From: Simon Davis
Sent: 15 June 2021 18:31
To: 'philip [REDACTED]'
Cc: 'christopher.best@arun.gov.uk'; Christopher Best
<christopher.best@arun.gov.uk>
Subject: AL/49/21/DOC - Springfield, Hook Lane

Your client contacted me this morning and asked that I provide an update on the application. Therefore, please see the following summary:

EAST ELEVATION
(1:50)

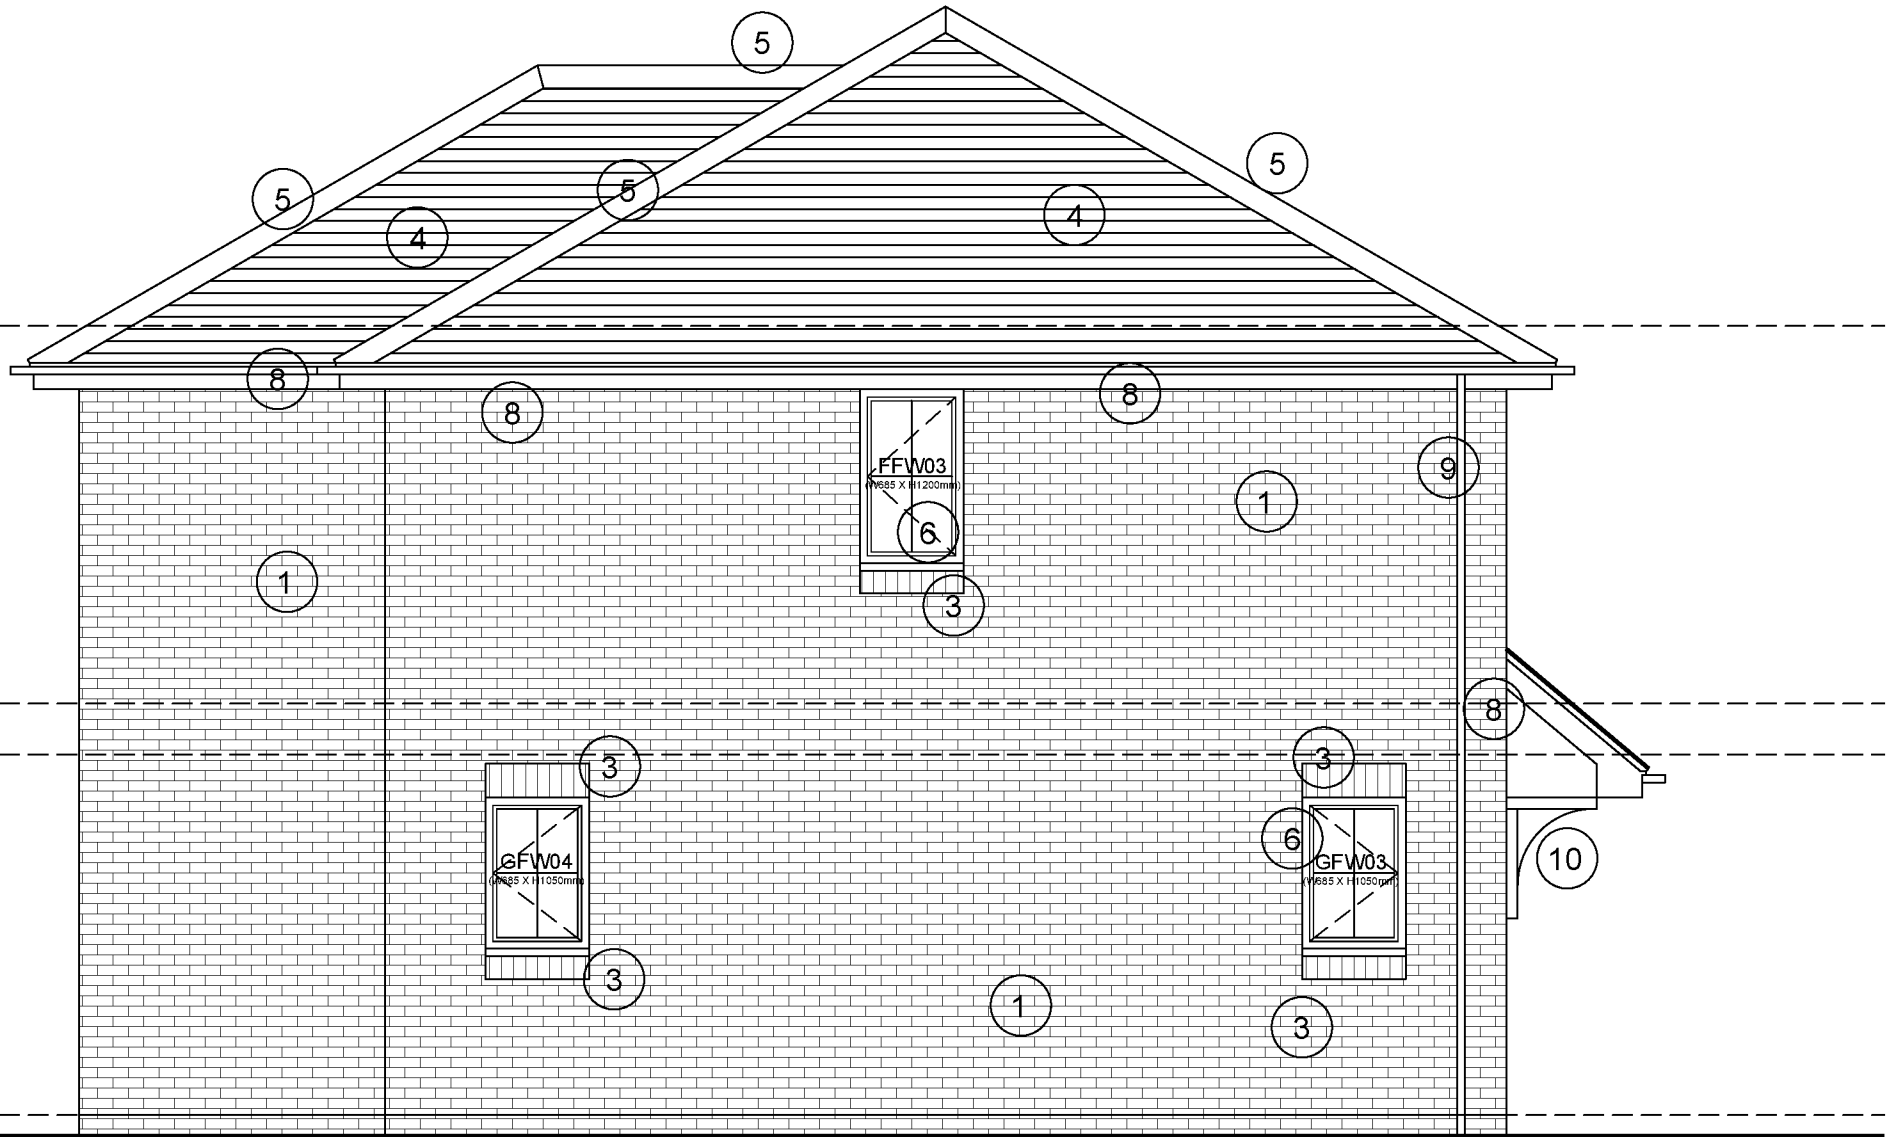
14	I have accepted the amended plans regarding the materials and I will be able to approve this.
15	As 13.
16	I did request that you respond within 10 days of my email dated 07/06 which you did meet. However, I have looked at the condition wording and see that it requires 24 new native trees but the plan provided shows only 12. I will therefore be refusing this condition on the basis of not meeting the condition requirements.
18	The use of Air Source Heat Pumps (as shown in the spec and the associated plan) is acceptable but there is no information to meet this part of the condition “.. <i>demonstrate that the development will achieve energy efficiency measures that reflect the current standards applicable at the time of submission ...</i> ” It is not appropriate to just propose
